Description: Removal part dwelling/club and addition of ground floor club/dwelling improvements with first floor s/c flat over

Location: Lake Ross
Dozens Bank
West Pinchbeck

Amendment: Reduced scheme to dwelling house only
(Dwg no. 2/1)

**TOWN AND COUNTRY PLANNING ACT 1990
NOTICE OF ACCEPTANCE OF AMENDMENT**

DRG. NO. 2/1

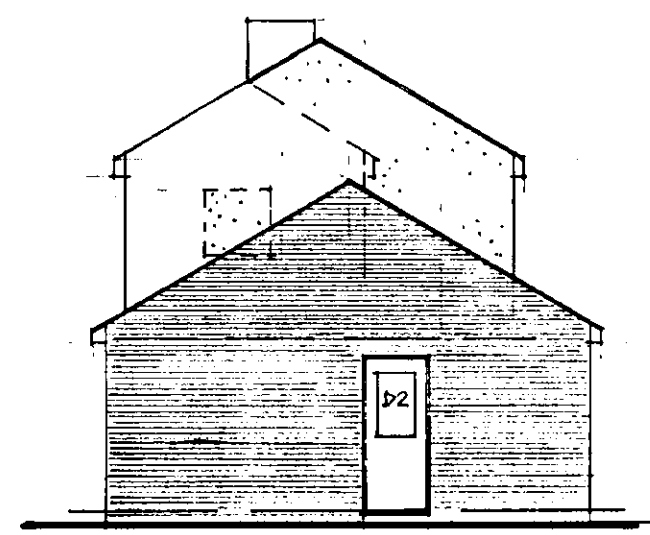
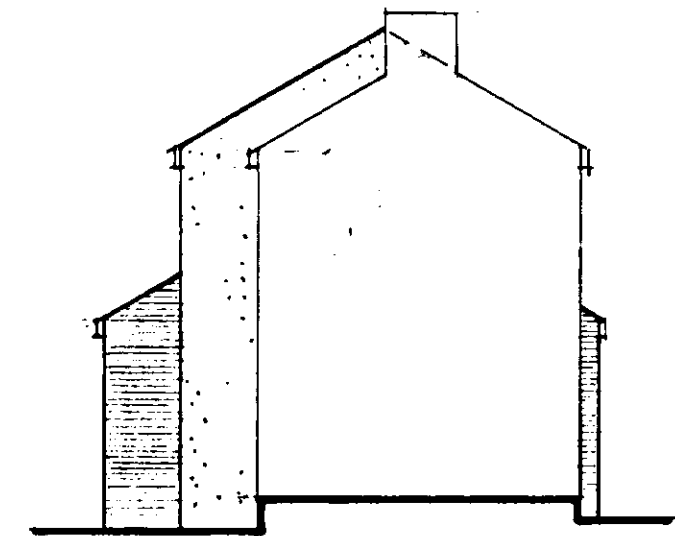
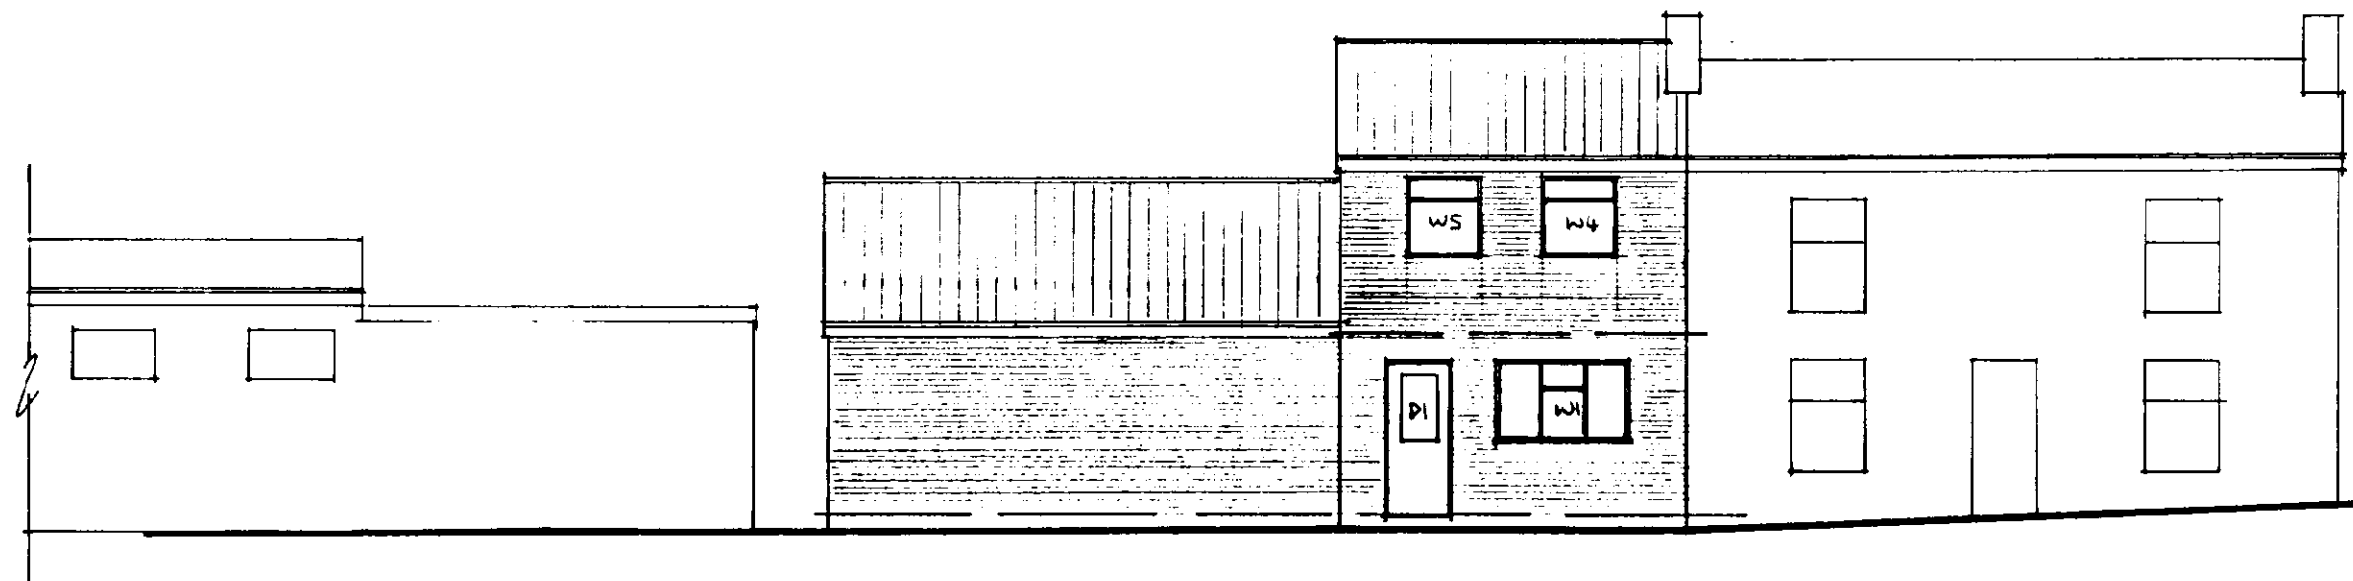
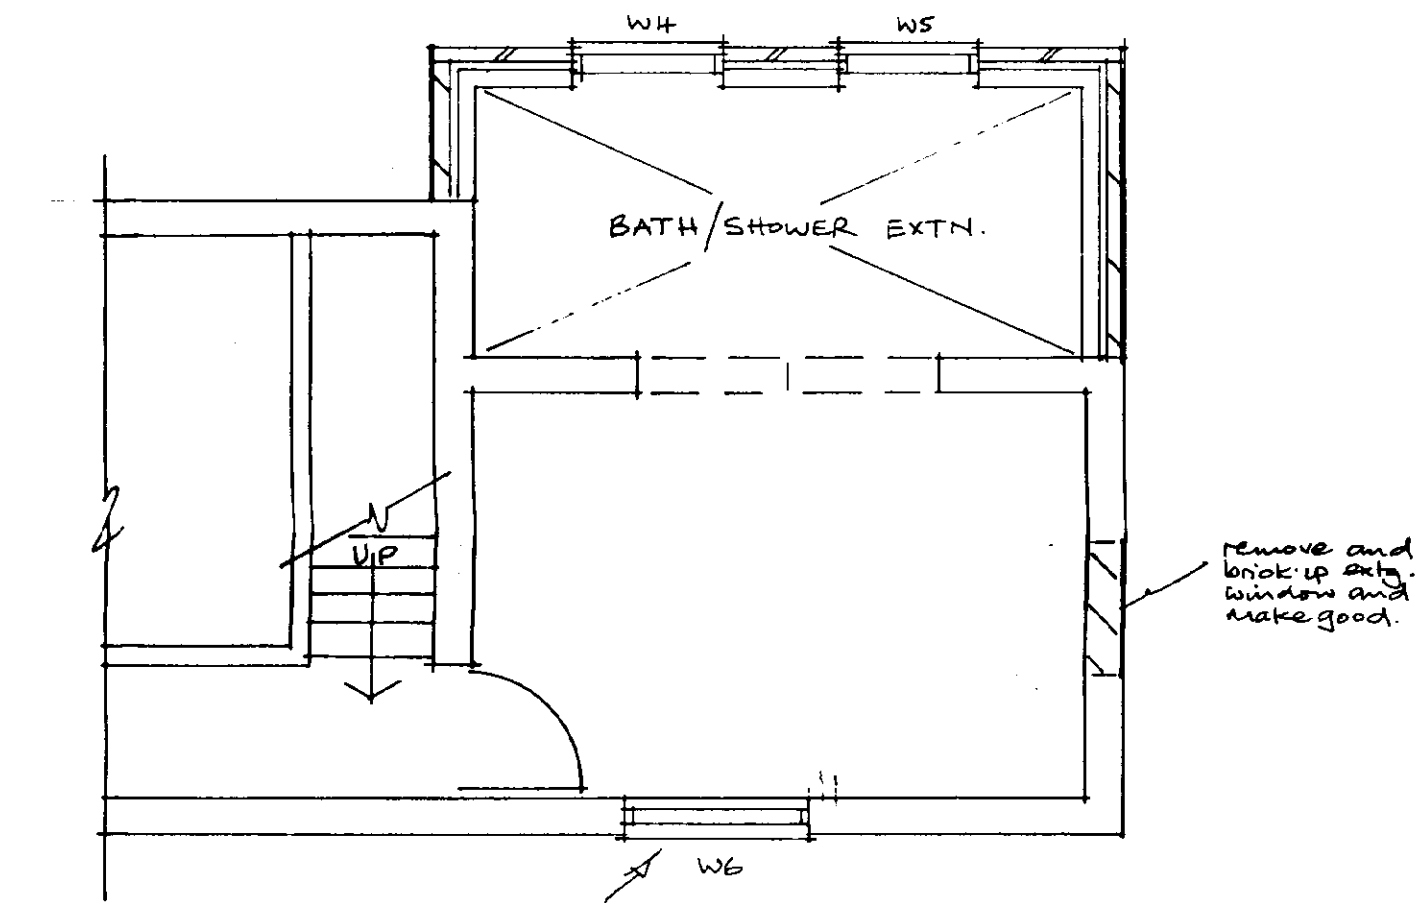
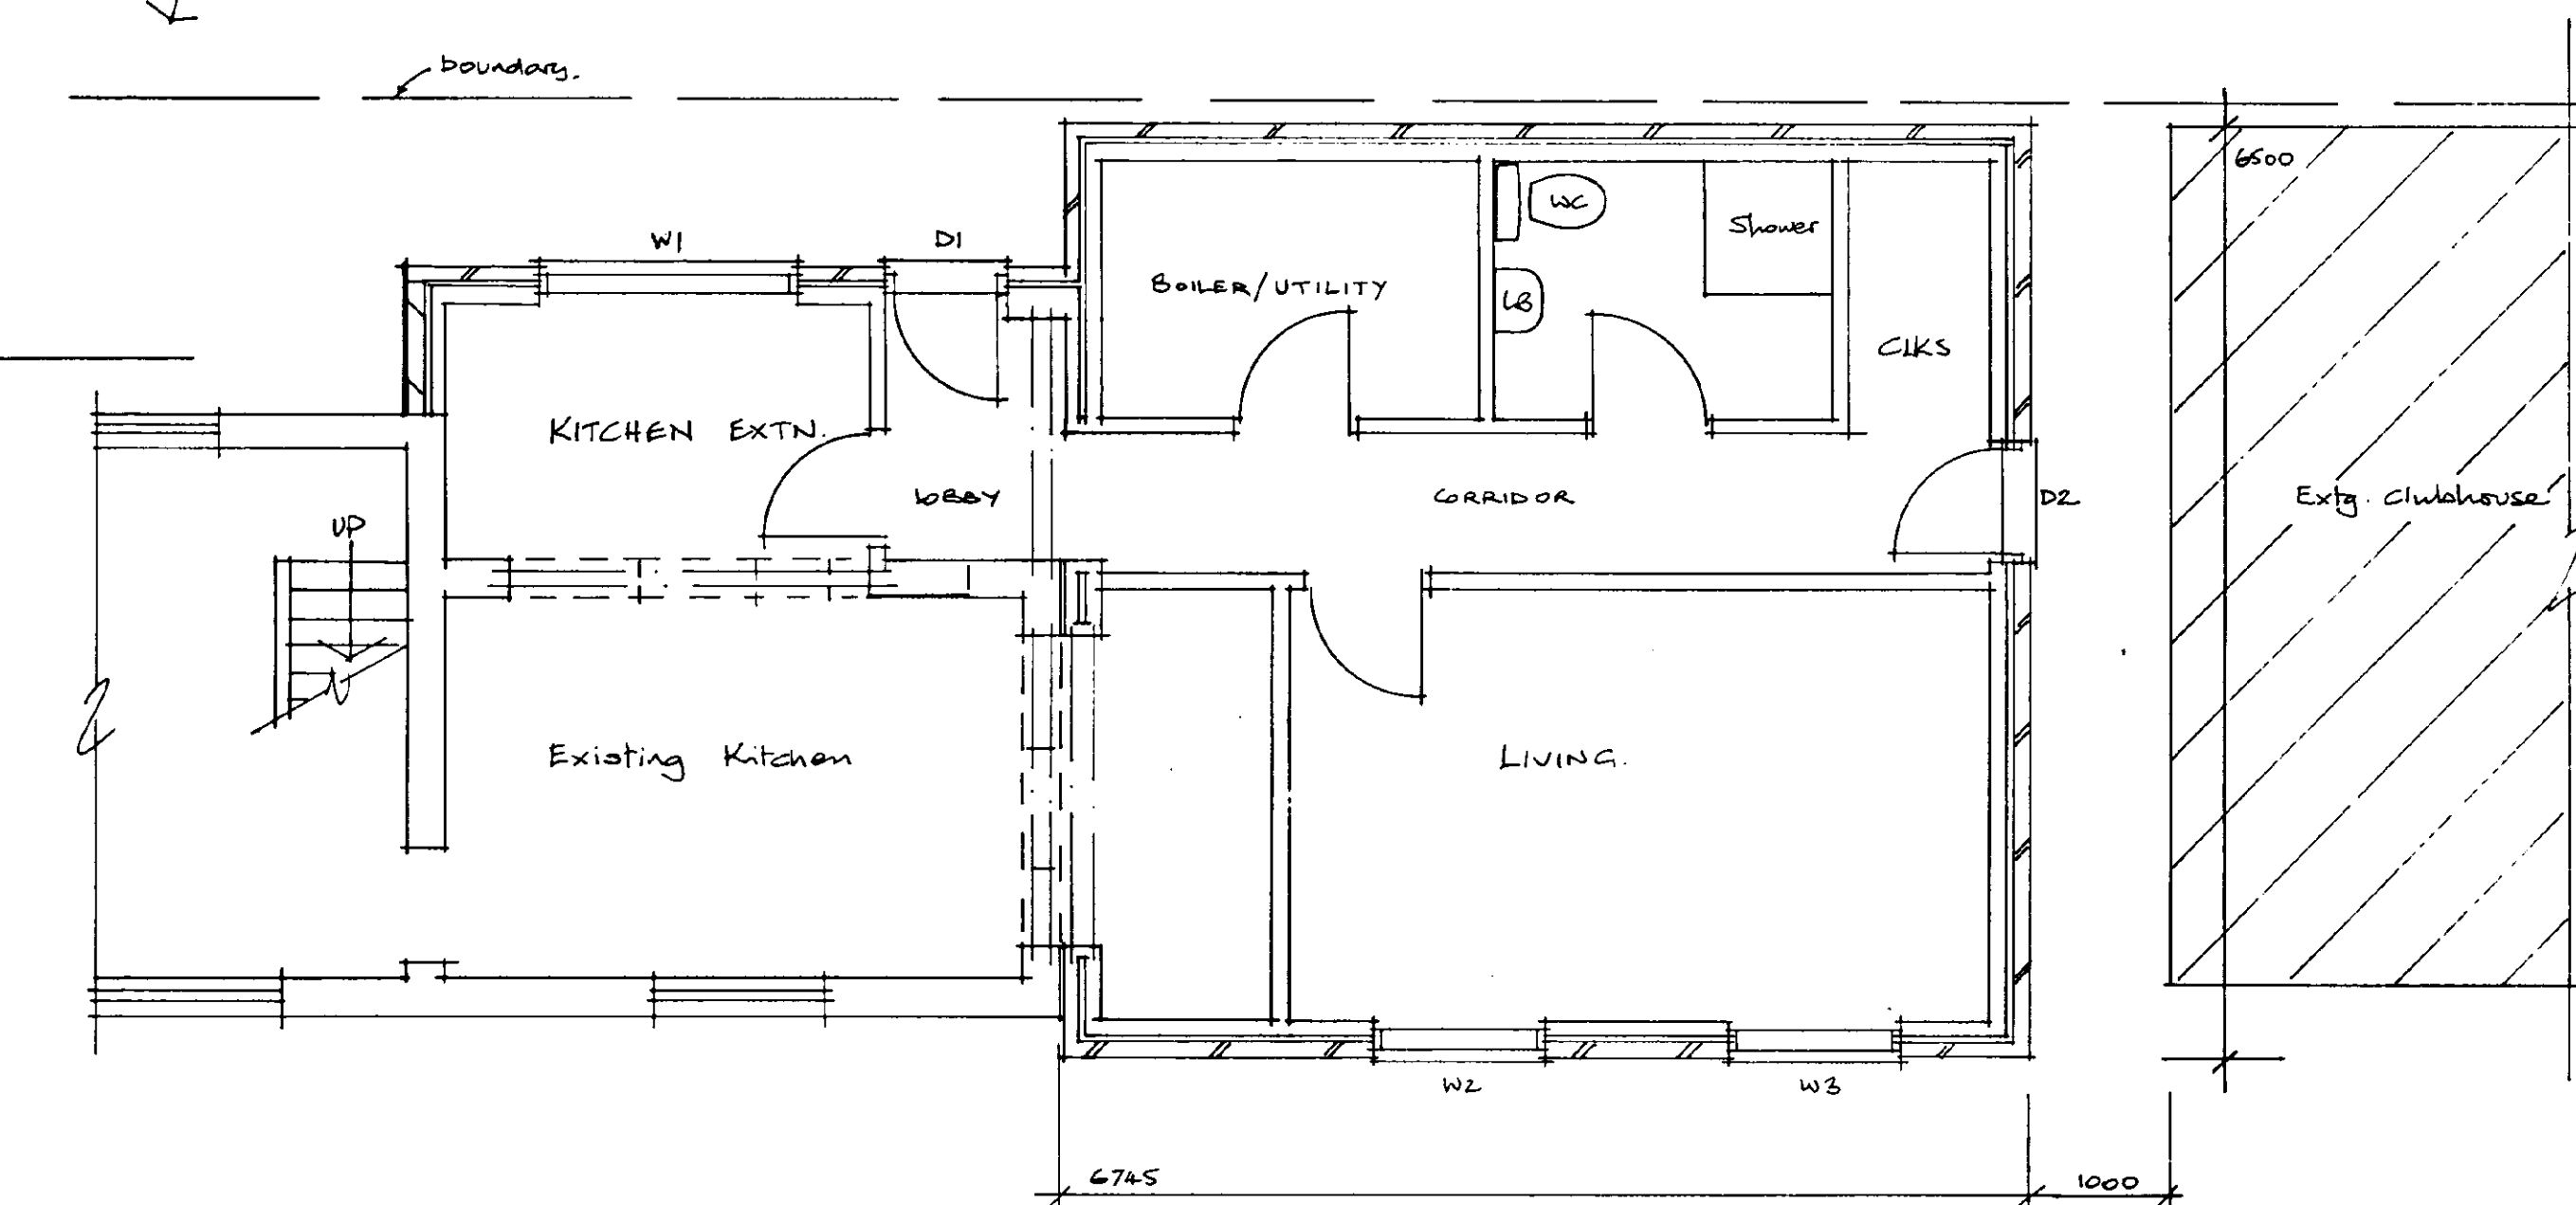
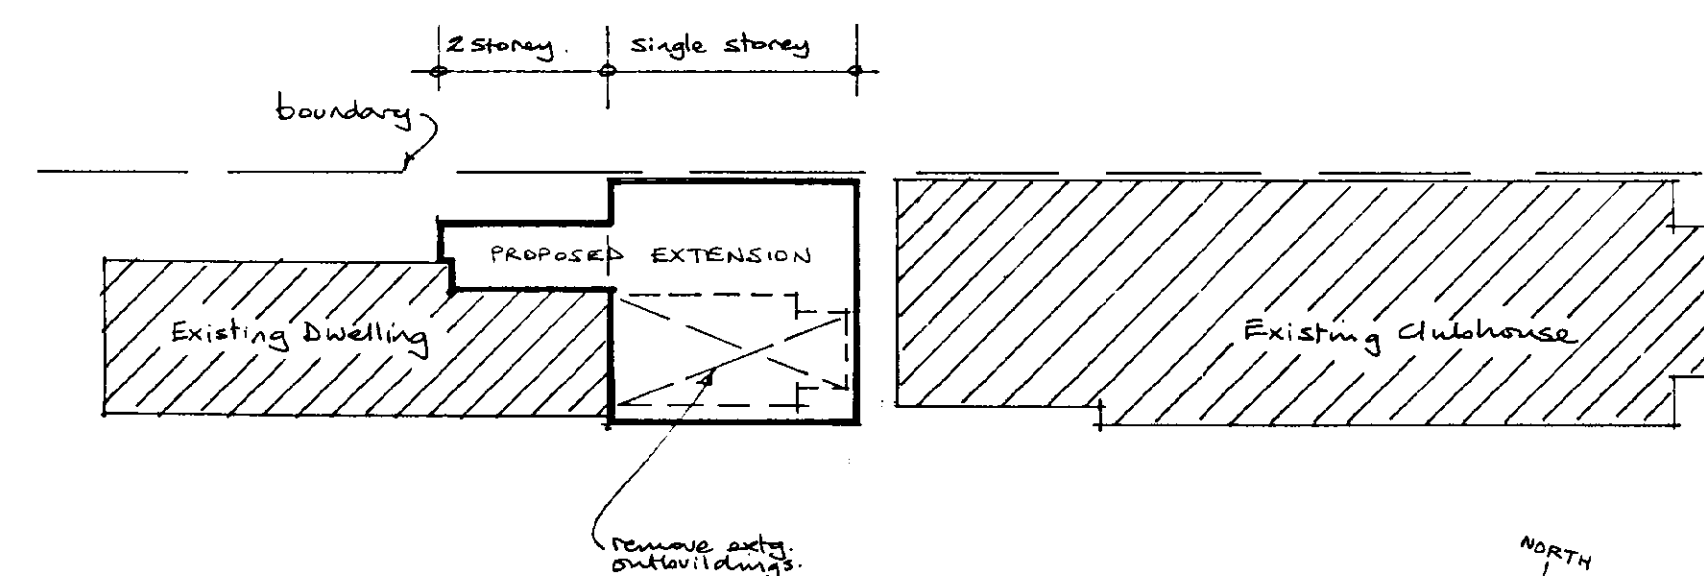
Further to the above Planning Permission dated 20 May 2002
my Client has decided to carry out a somewhat reduced scheme
and I enclose a copy of drg. no. 2/1 to show the proposals.

You will see that the alterations purely affect the dwelling,
leaving the club as existing.

The amended details submitted in respect of the above proposal have now been considered and there are no objections to the amendment being implemented to the extent described above.
